13th November 20

Re : planning application AB/105/13/L --- AB/104/13 River Road Arundel

Drawing
Houses 5-6 & 7
Elevations

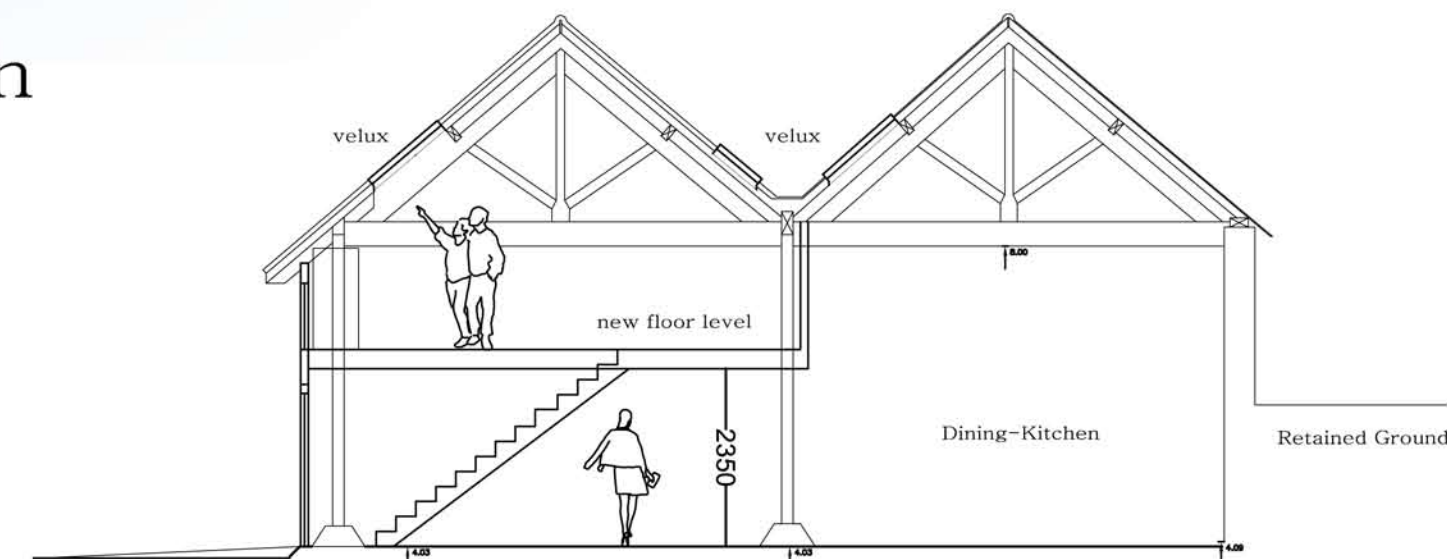
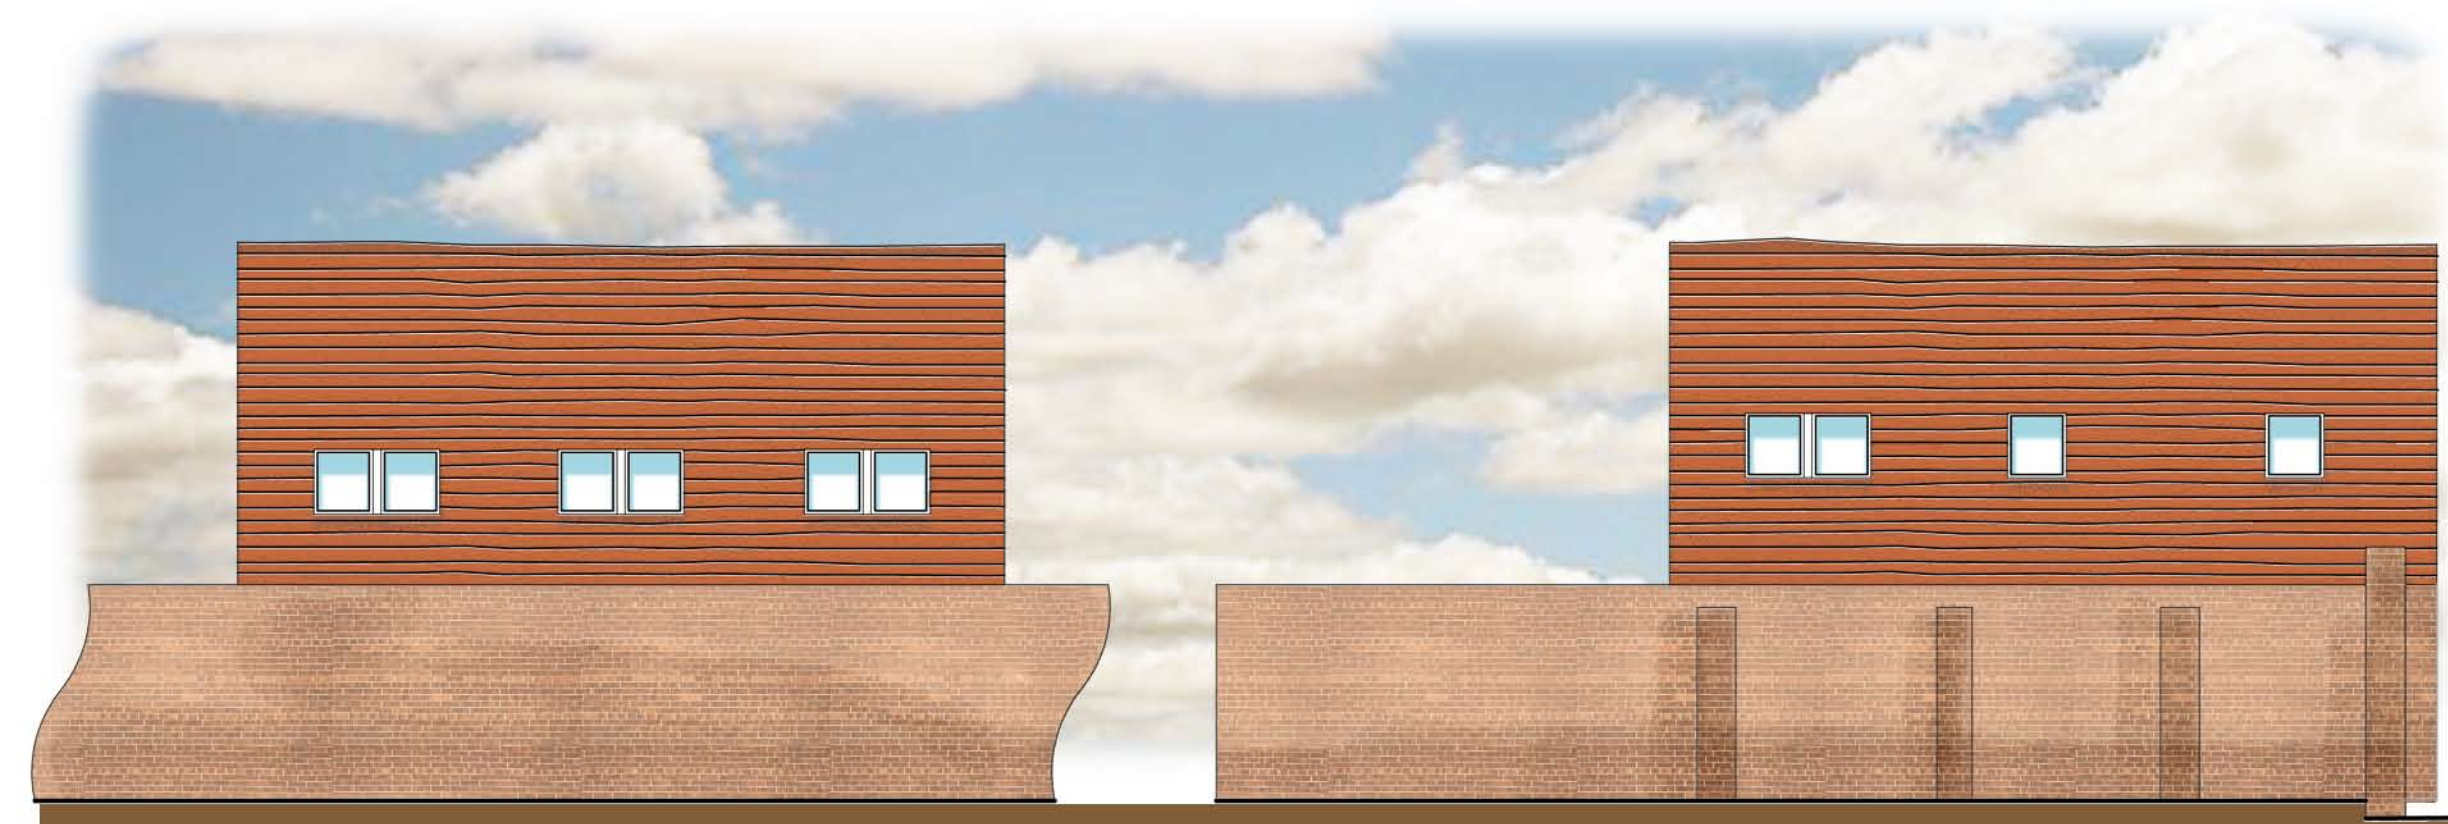
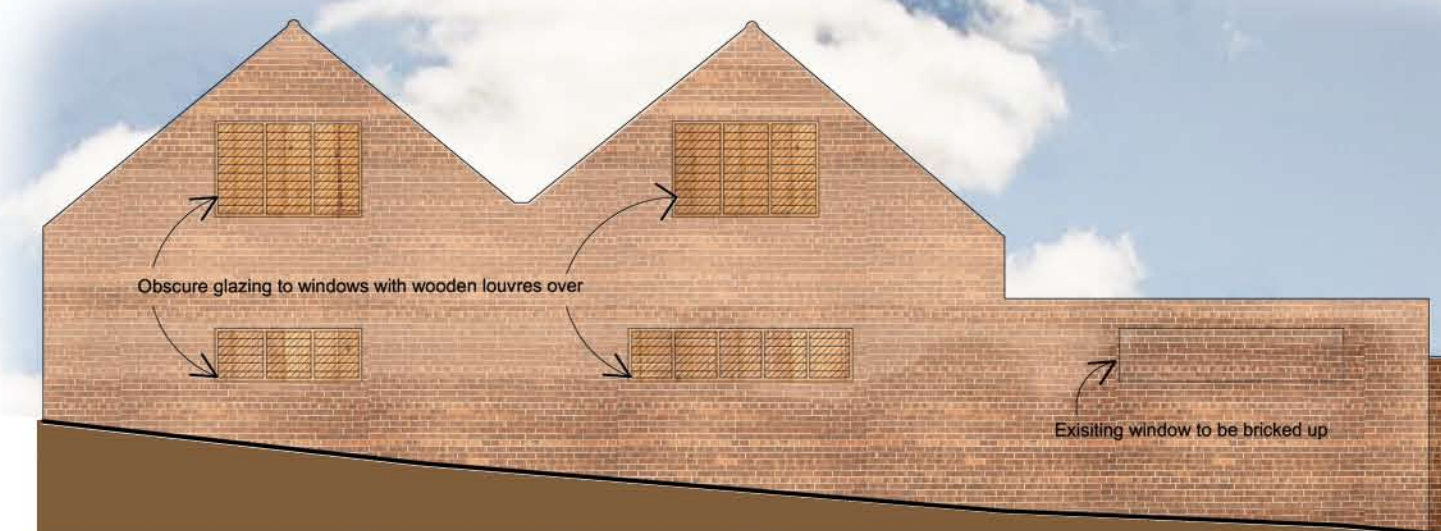
1/. The proposed buildings running along side of the wall could be positioned further West to give more light to the Houses 1 and 3 in Brewery Hill. At the moment No 1 is very dark due to the very high wall opposite the house and the proposed roofline will make it even gloomier. The same applies to No 3

Drawing **Houses 10 & 11** Scale:@A3 **1:100**

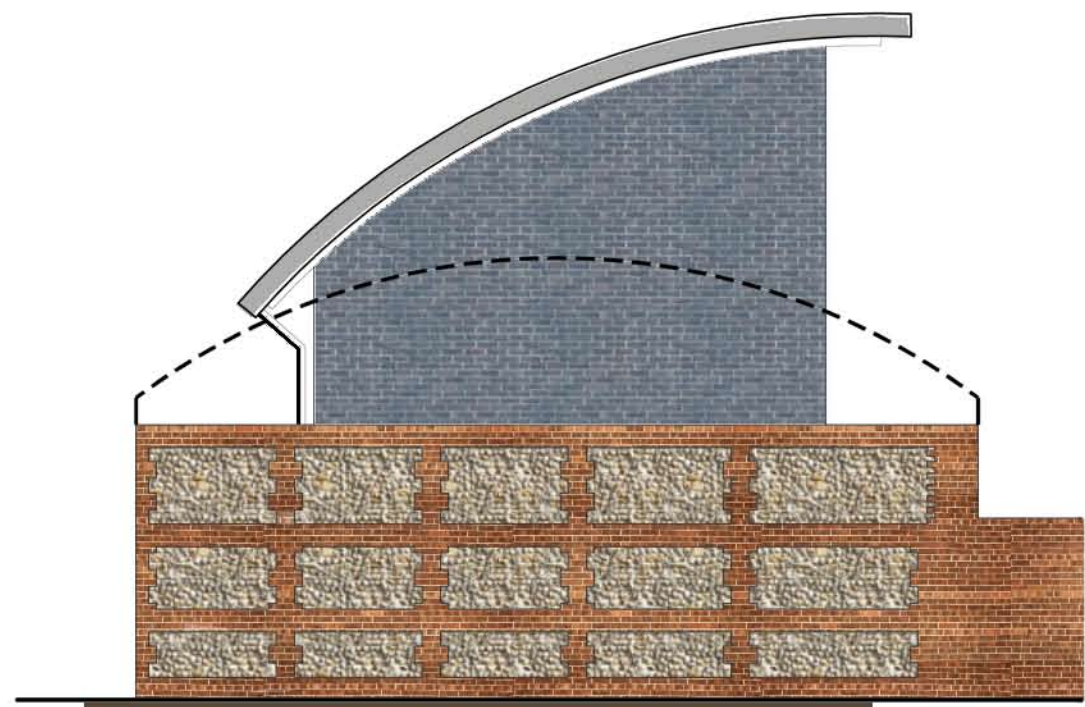
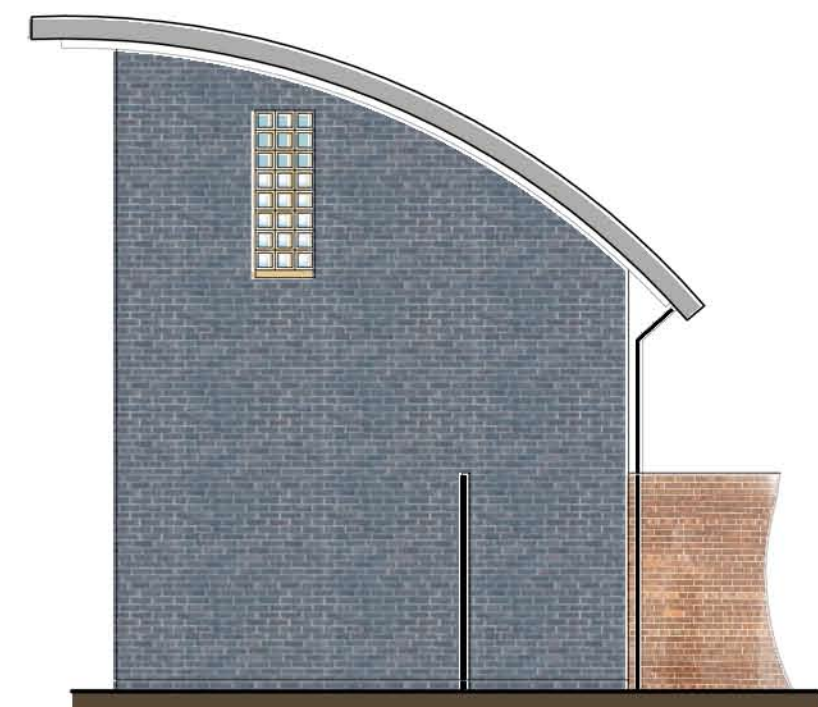
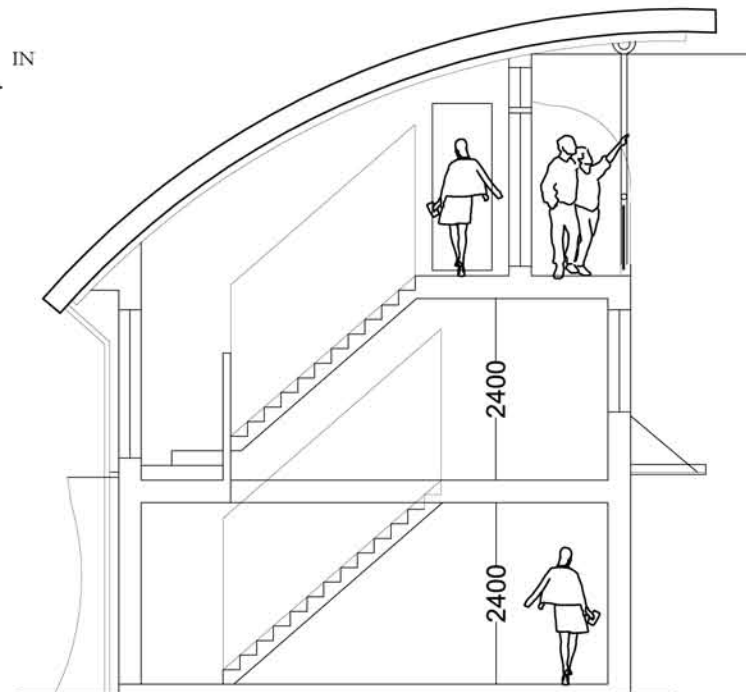
3/. The roofs of the dwellings Nos. 7- 8 - 9 -10 -11 - 12 -13 seem to be made of metal. And the houses on the South West corner have a silly curved shape - I suppose to mimic the shape of the existing corrugated iron Dutch barn. These dwellings should have tiles to match the existing listed buildings.
